**Consultation Response from KC,
Lead Local Flood Authority**

2023/92347 Longley Park Motors Ltd, The Triangle, Paddock, Huddersfield, HD1 4RU

Demolition of existing car sales building, canopy and forecourt; change of use to include vehicle car rentals and sales; leveling of site; installation of cabin; construction of vehicle wash bay; installation of vehicle barriers; drainage and hardstanding work

Date Responded: 11th September 2023

Photograph Seven: Three-chambered forecourt drainage interceptor (unconfirmed - chamber lids rusted/silted shut).

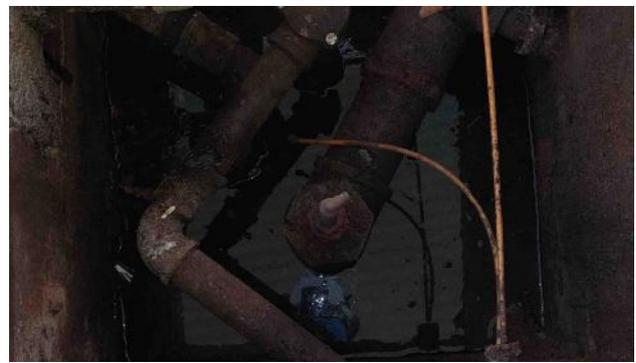
- Give the size of the site and nature of the operation, an oil/petrol interceptor will be required.
- The area where vehicles are washed cannot connect into the interceptor as it will cause oils and water to combine. A separate connection will be required to a combined/foul sewer system. A suitable silt trap will be required.
